TfNSW Reference: SYD19/00528/02

Department Reference: SSD 10313

WESTERN SYDNEY GREEN GAS PROJECT – 194-202 CHANDOS ROAD, HORSELY PARK

Figure 6 | Site access route. Blue line shows the originally proposed route in the EIS and the red line shows the revised route, as proposed in the Submissions Report (Source Submissions Report - Western Sydney Green Gas Project).

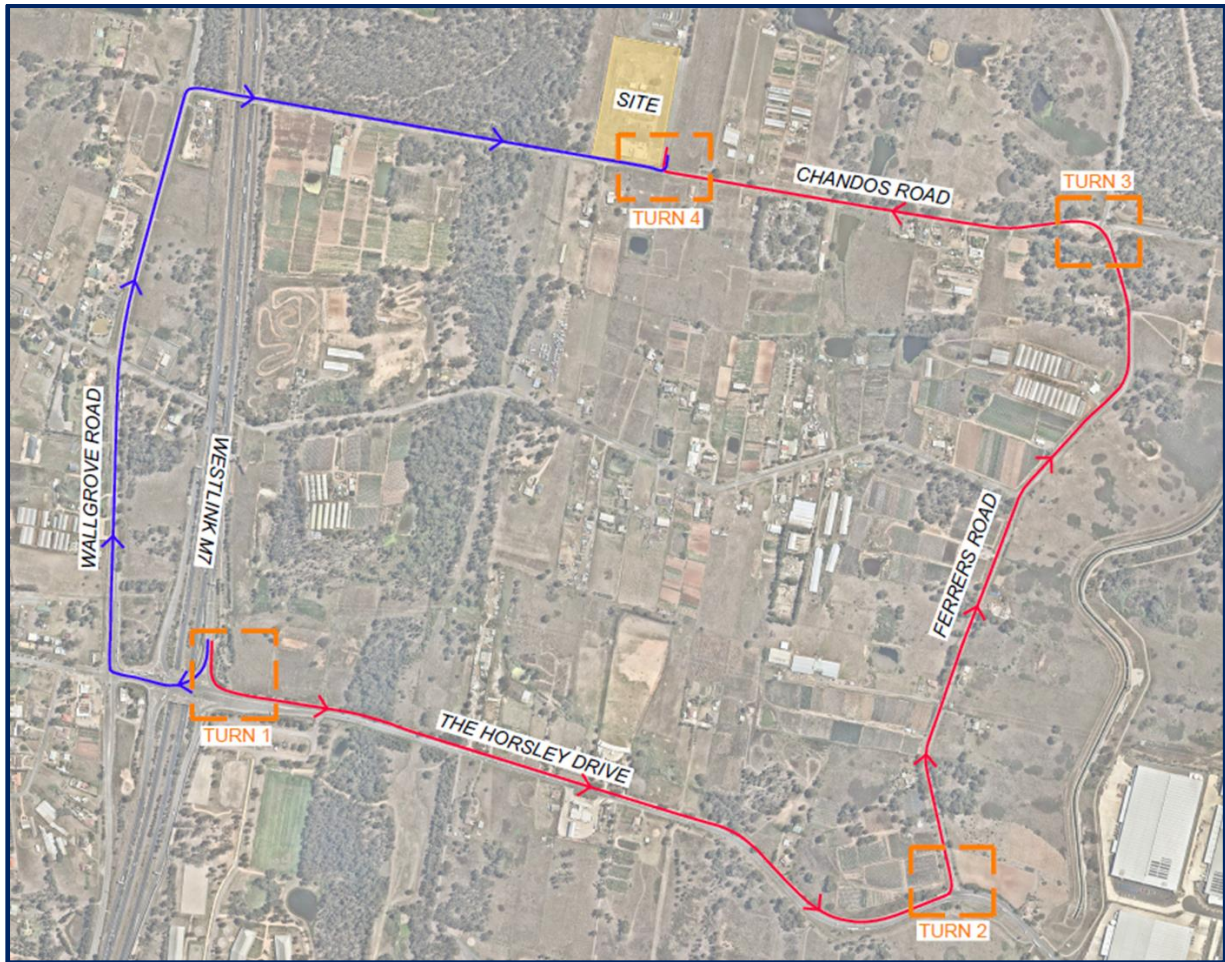
1. The intersection of Wallgrove Road and Chandos Road has been identified as a blackspot site and TfNSW has recently reduced the speed limit along this section of Wallgrove Road. TfNSW has safety concerns with construction vehicles using this intersection. TfNSW requests that this vehicle route be further assessed.
2. It is noted that Chandos Road has a '5t and over' weight restriction. While Council is the responsible authority for this local road, it includes an overpass of the M7 Motorway. TfNSW requests information on how the applicant plans to address this weight restriction.
